From: Maria Tomalova <Maria.Tomalova@arun.gov.uk>
Sent: 17 February 2020 18:55
To: Planning.Responses <Planning.Responses@arun.gov.uk>
Subject: FW: Planning Consultation on: BN/66/19/PL

Subject: Planning Consultation on: BN/66/19/PL

APPLICATION NO: BN/66/19/PL

Description of Works: Erection of 3 No dwellings.

Studio Lack Architecture Studio Lack Ltd : 17 Beech Avenue : Chichester 01243 782 686 : nicholas.lack@live.com : PO19 3DR	Land off Canal Mews Barnham	Site Layout 11/01/20 1/200 @ A3	Dwg 1705-12H
--	--	---	---------------------

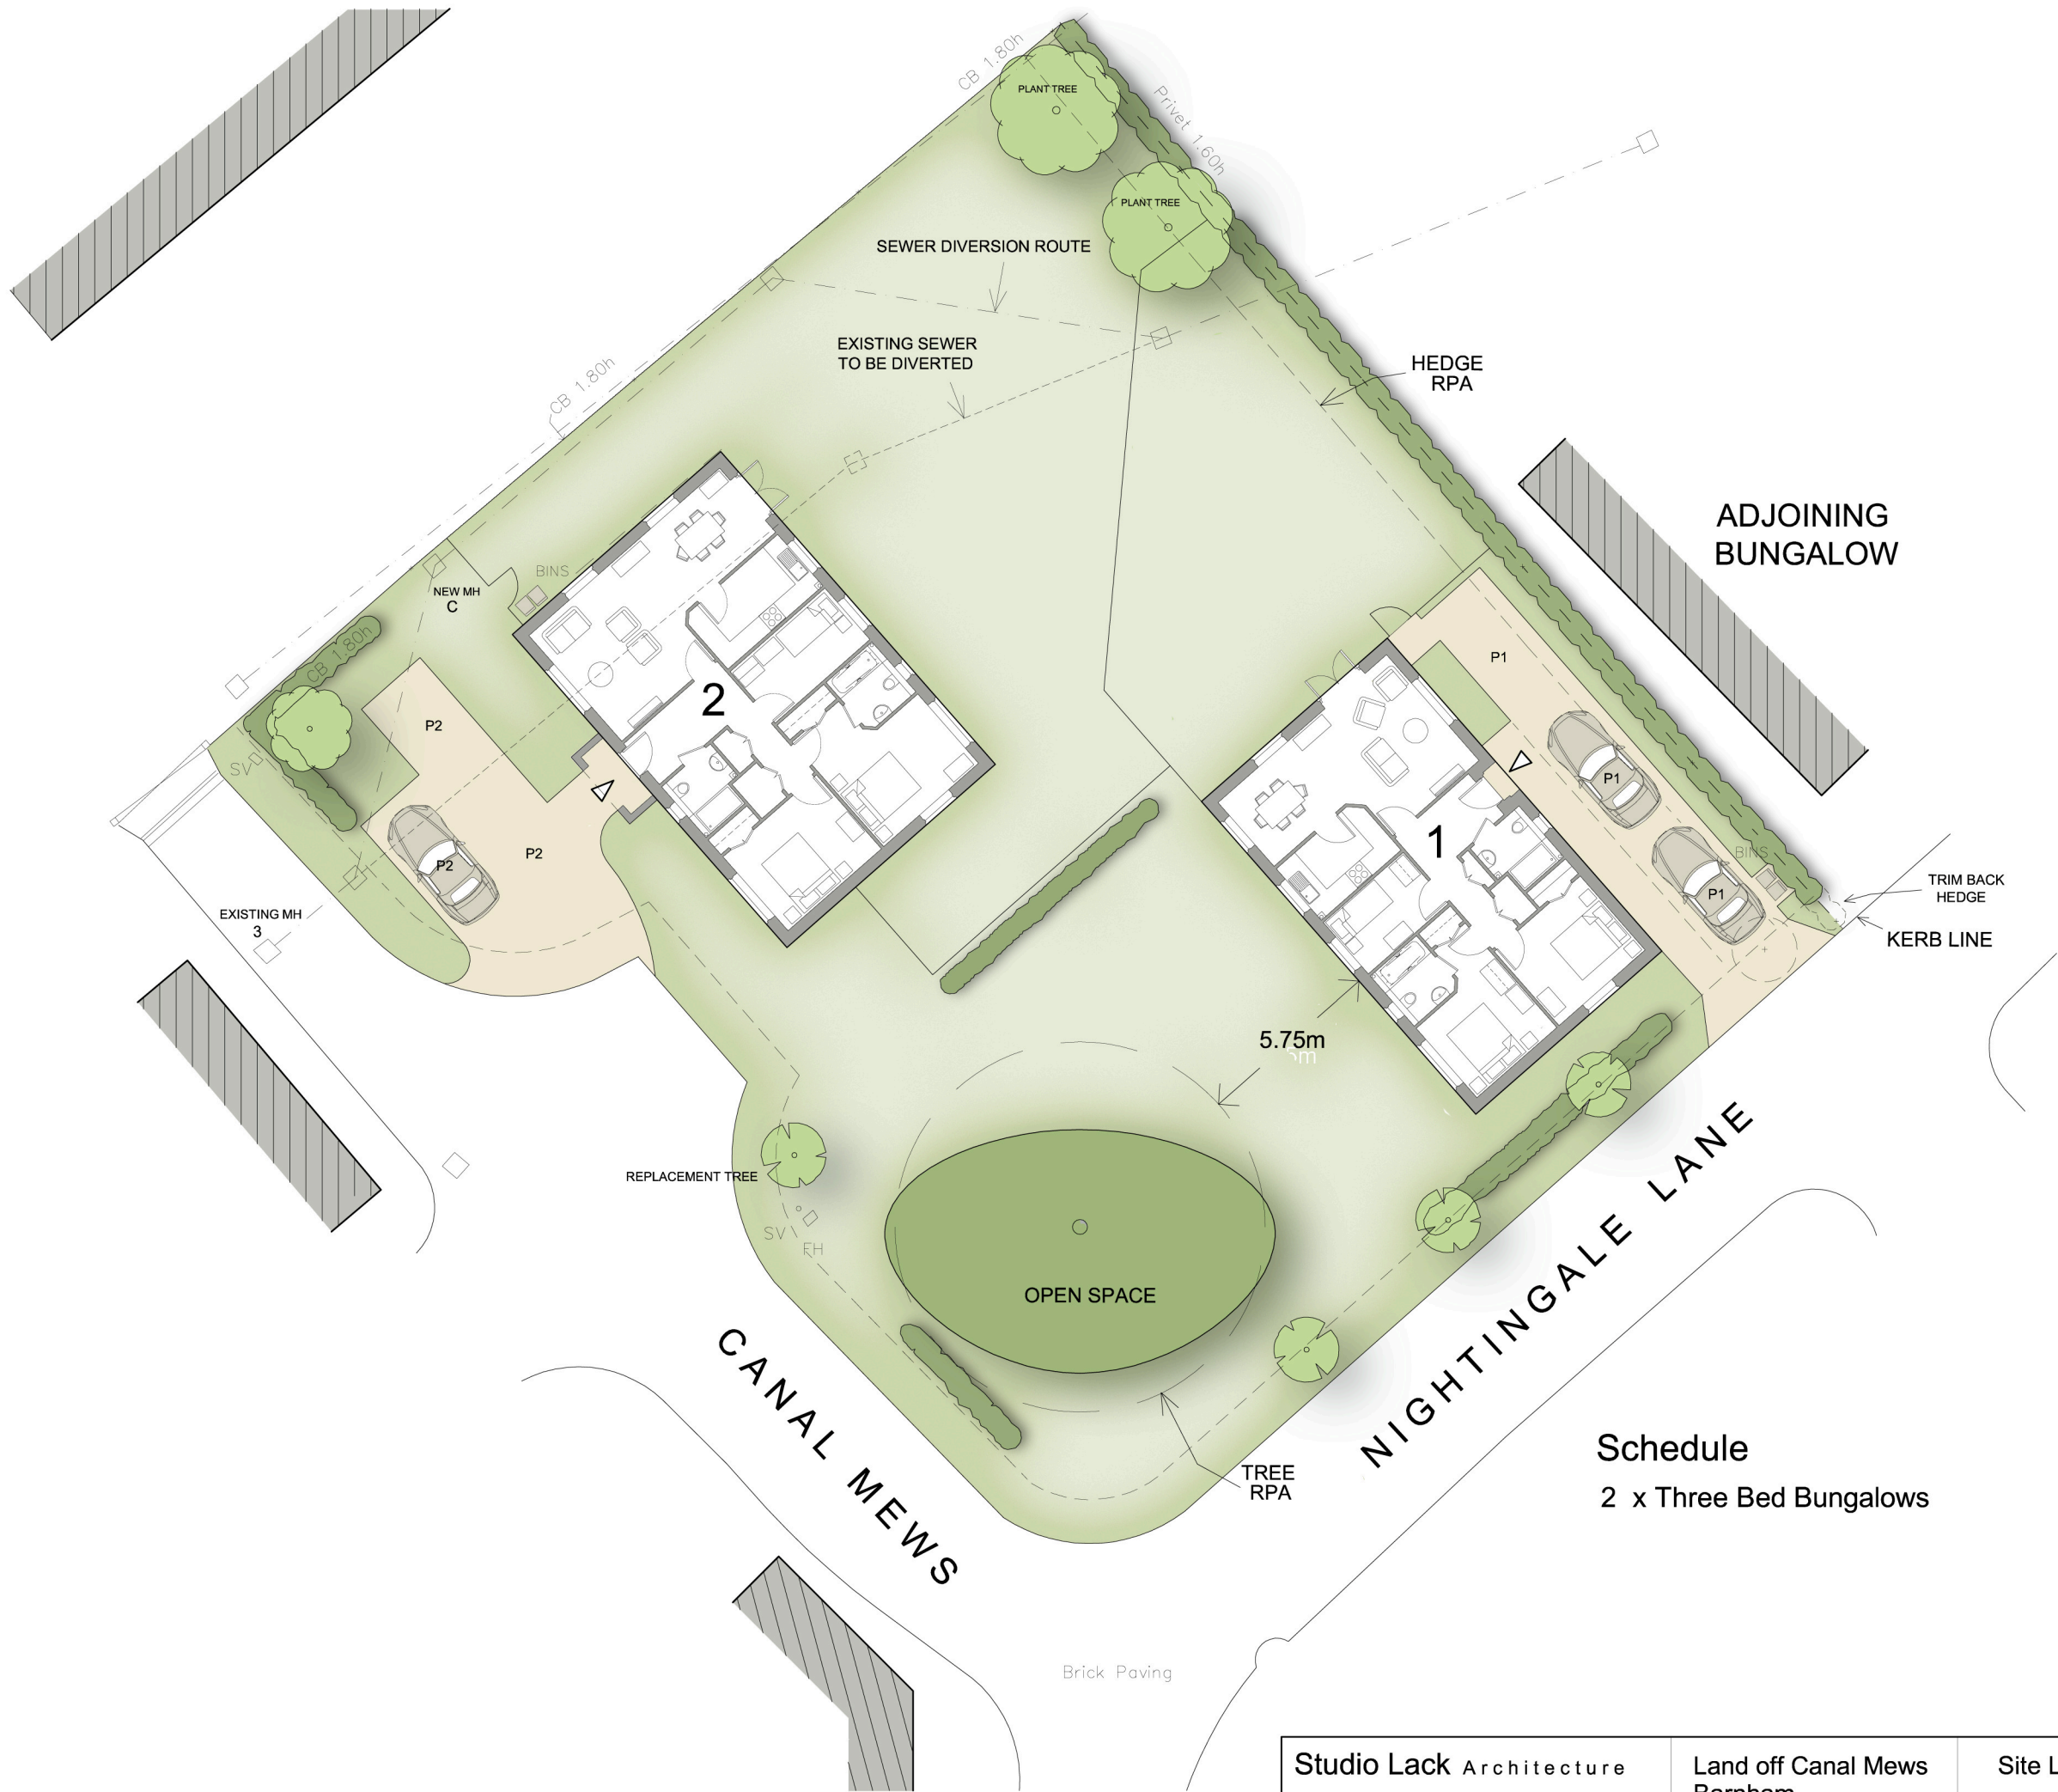
In response to your enquiry; the applicant has conferred with Croudace Homes who verify that apart from one foul sewer crossing the site, which we are proposing to divert, nothing else exists below the site to affect our proposed development.

What we think has happened in relation to Laura Gibbons comments, and one of the residents is that originally our application site was earmarked for a sewerage treatment plant but this was never constructed as it was found to be feasible to connect all the houses to the existing foul water sewerage system directly. Perhaps they are citing out of date drainage plans?

Rev	Description	Initial	Date
Croudace HOMES.CO.UK			
BARNHAM GOODACRES			
GENERAL LAYOUT SHEET 2 OF 2			
SCALE:	1/200 @ A0		
DATE:			
DRAWN:			
CHECKED:			
DRG.No.:	000/000

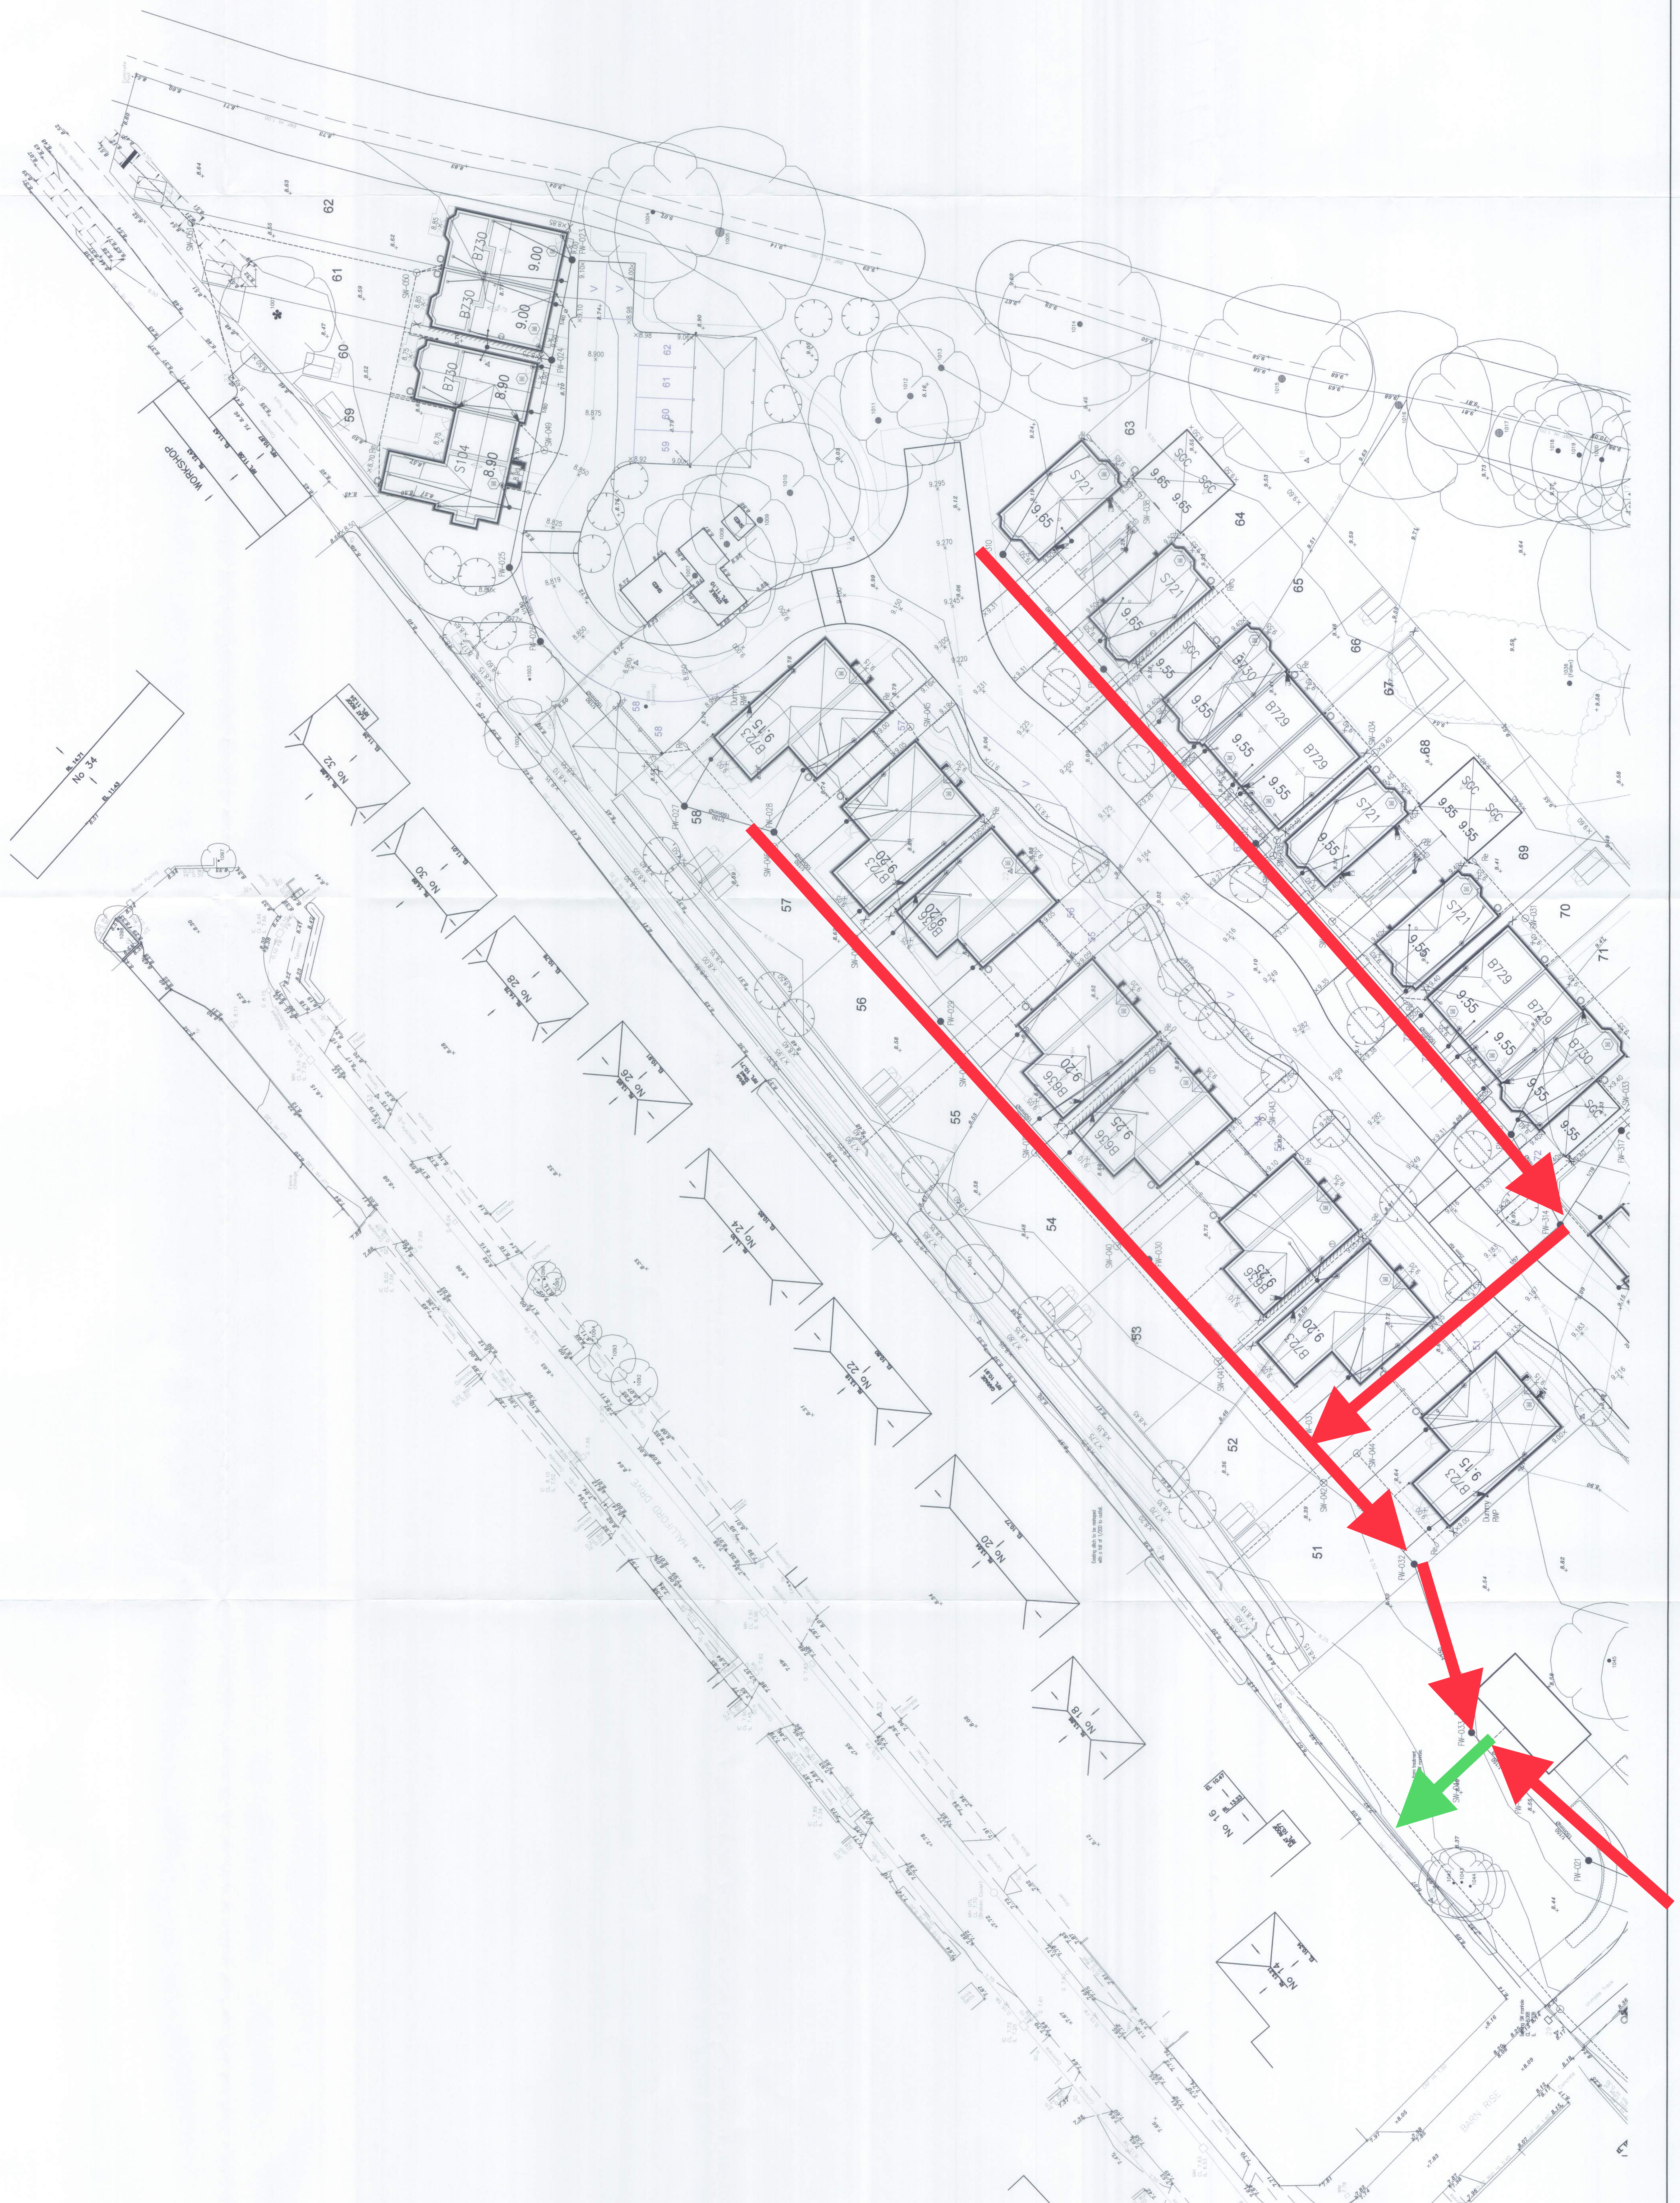
The development site 'Good Acres' has been approved under reference BN/13/14/ and under BN/25/14/DOC the condition 7 (Foul Water System) has been discharged: 'A gravity sewer will collect foul water and convey it to the proposed treatment plant south of the emergency access off Barn Rise.' accompanied by the drawings showing the plant on the site.

If the plant is not in the ground and the changes have been done without consent from the Local Authority, it would be considered as a breach of condition.

Therefore I still insist on the provision of the decision notice from the District Council approving the amended drawings.

The applicant has been in discussion with Croudace Homes and obtained the two attached letters from Southern Water confirming that the foul drainage system has been connected directly to the mains drainage, 'underground storage tanks' were not installed.

That is correct, at the time of submitting to discharge the planning conditions we were progressing the treatment plant option, however our drainage strategy statement does mention that we were exploring connection to the public sewer with Southern Water. We were in discussions with Southern Water in tandem with the treatment plant option. At some stage during this Southern Water agreed to the direct connection (see attached approval letter and inspection certificate)
